Engineers Comments Regarding Surface Water Drainage

Application Reference:	WA/49/26/HH	Reviewer Reference:	ADC/EXT5/AF
Planning Officer:	Jonny Cooper	Date of Review:	10/07/2026
Site Name:	Foxgloves Avisford Park Road Walberton BN18 0AP		
Application Description:	First floor rear extension		
Assessment Number:	1

GROUND FLOOR PLAN

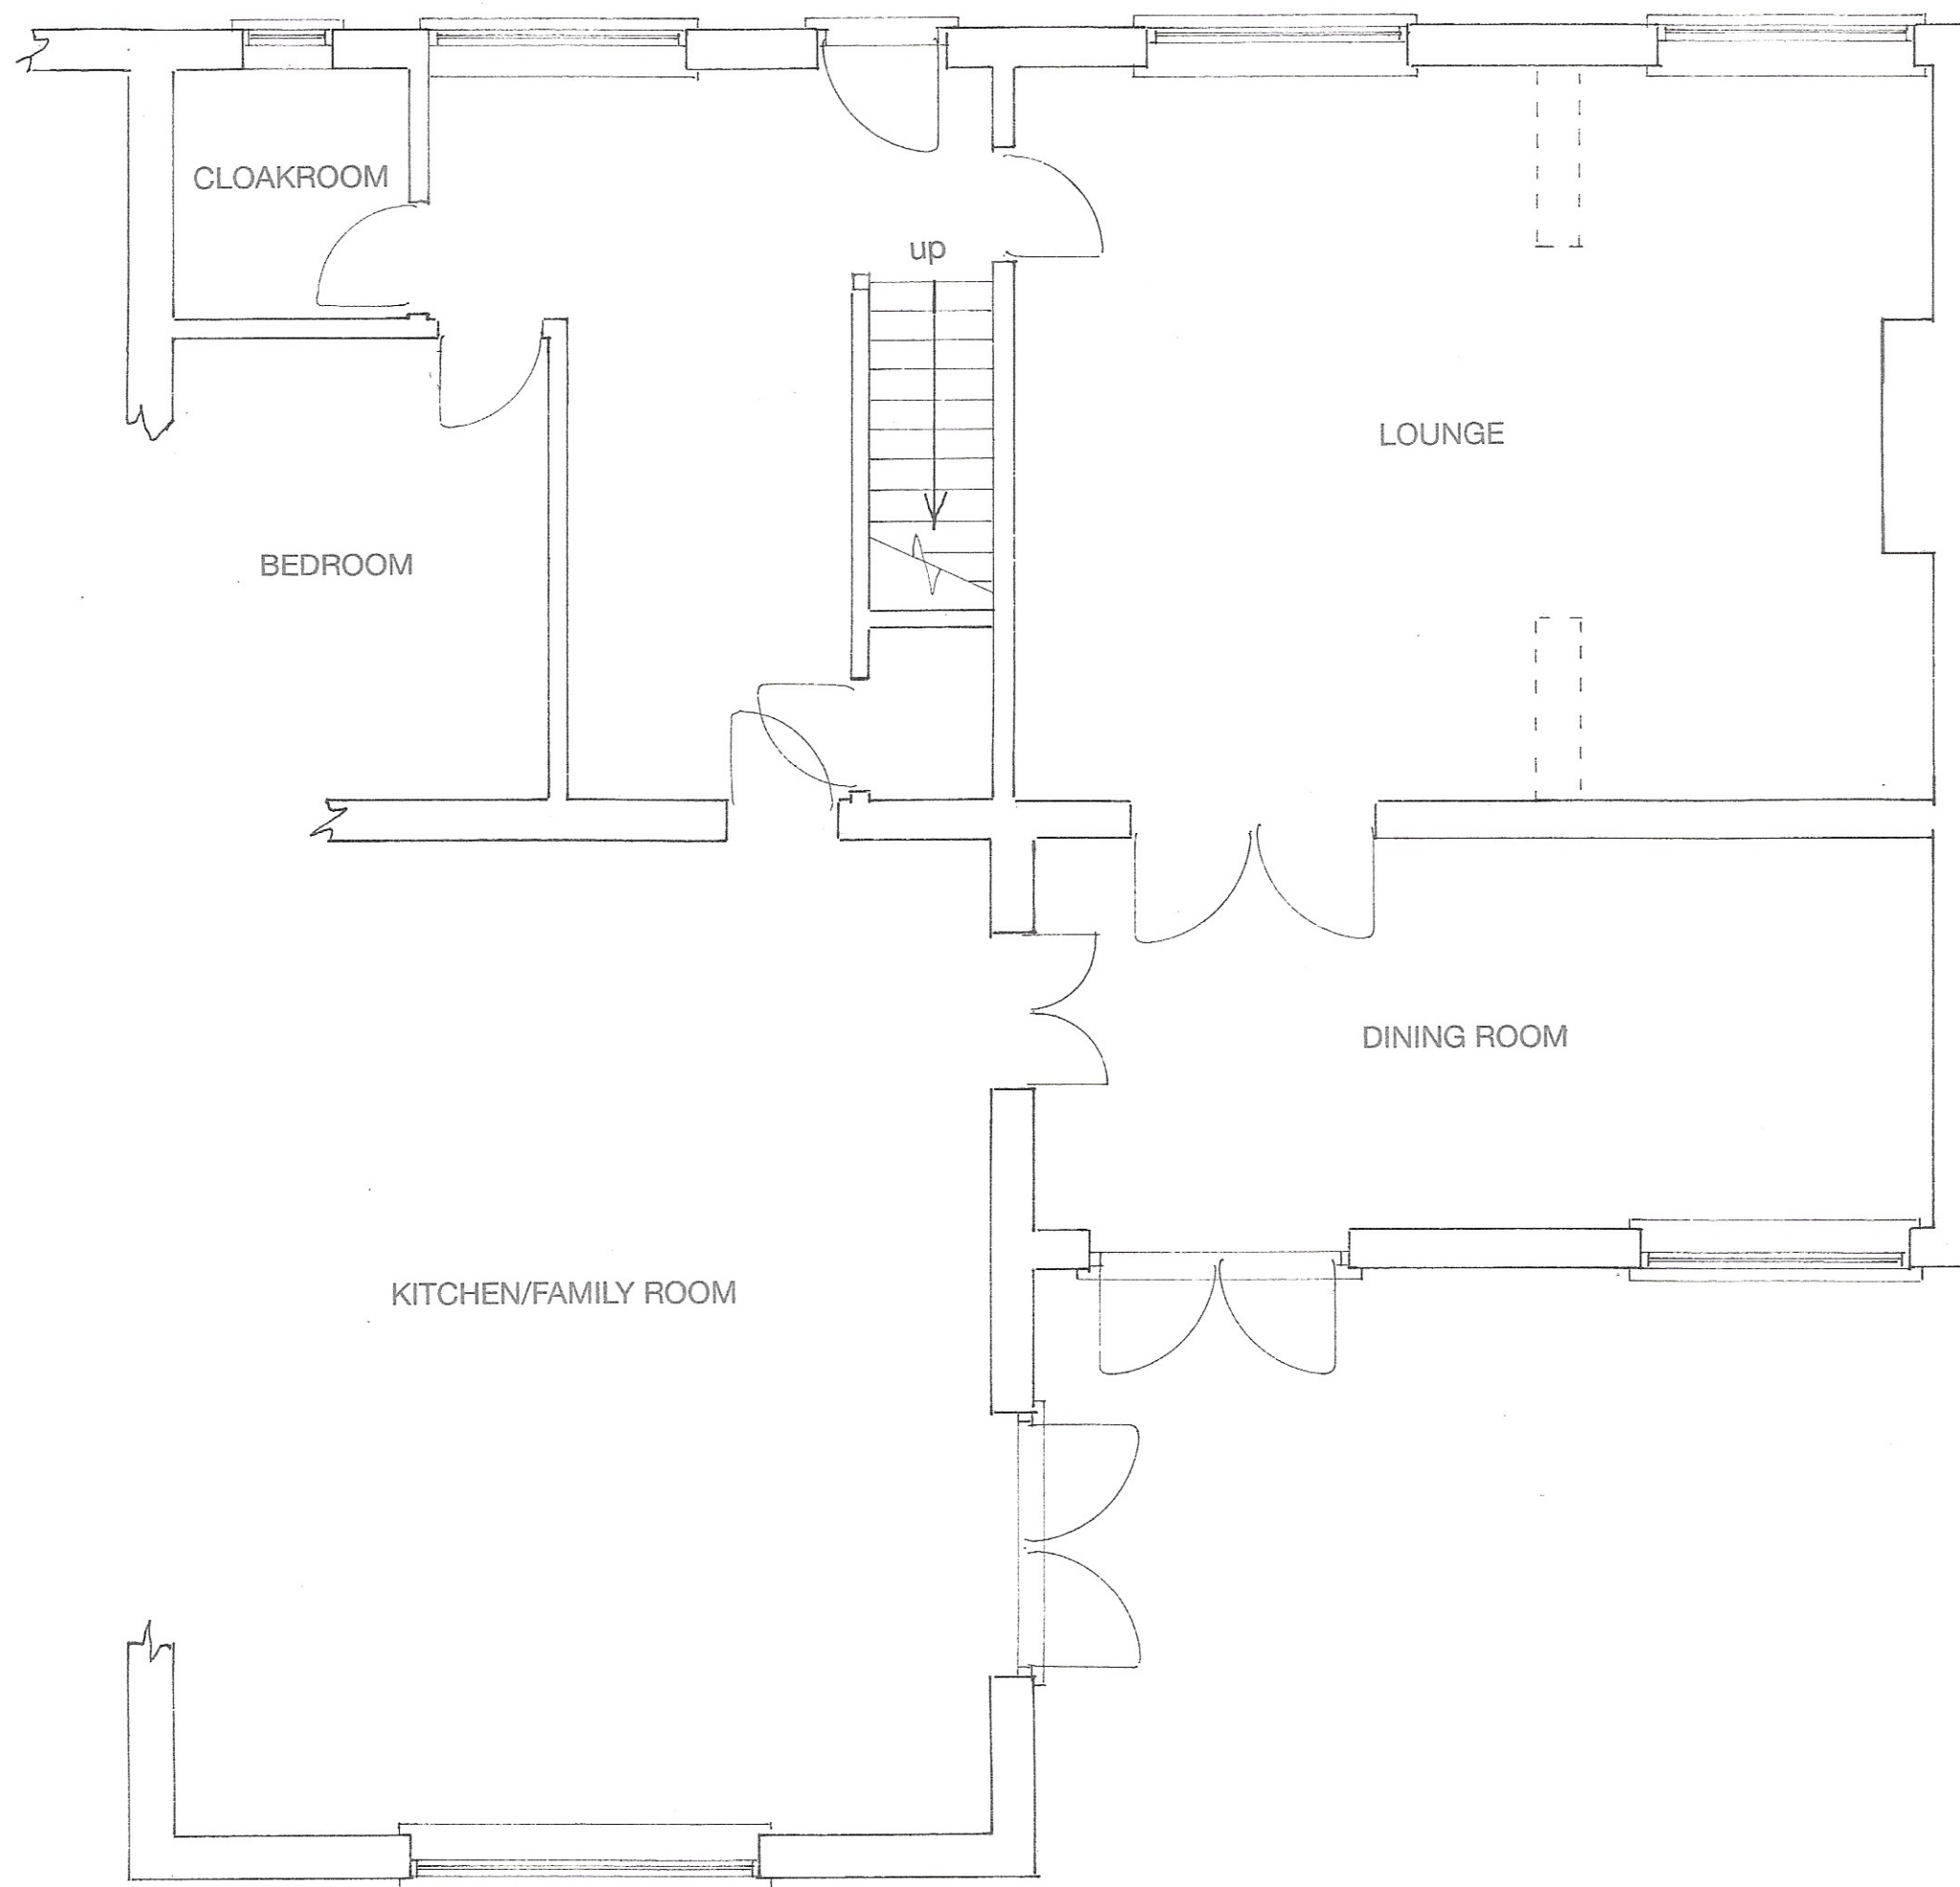
- 4.1. No assessment for water quality is provided with the application and water quality mitigation is not currently incorporated into the design.
- 4.2. However, there is no new trafficked areas shown on the layout and measures to mitigate runoff from roof areas can be integrated at technical design stage.

PROPOSED ROOF PLAN

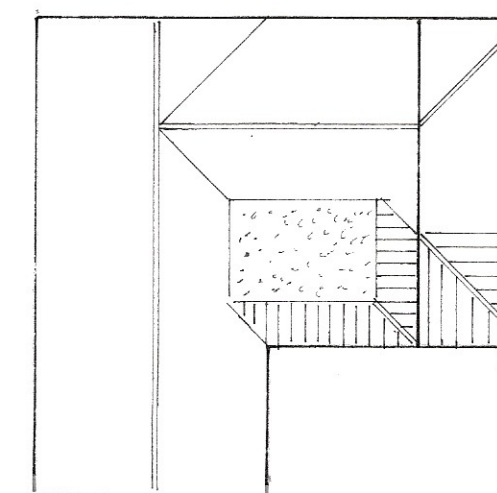
- 3.1. The outline calculations provided for the drainage system are not in accordance with sustainable drainage standards. The additional area should be attenuated, or the infiltration feature sized to accommodate large return period storms.
- 3.2. The drained area should be clarified and runoff calculated for the design storm based upon up to date rainfall data. Guidance is provided on ADC webpages - <https://www.arun.gov.uk/surfacewater>.
- 3.3. Management of extreme rainfall is not currently in accordance with the requirements of the NSfS Standard 3. Therefore, we **object** to the application.
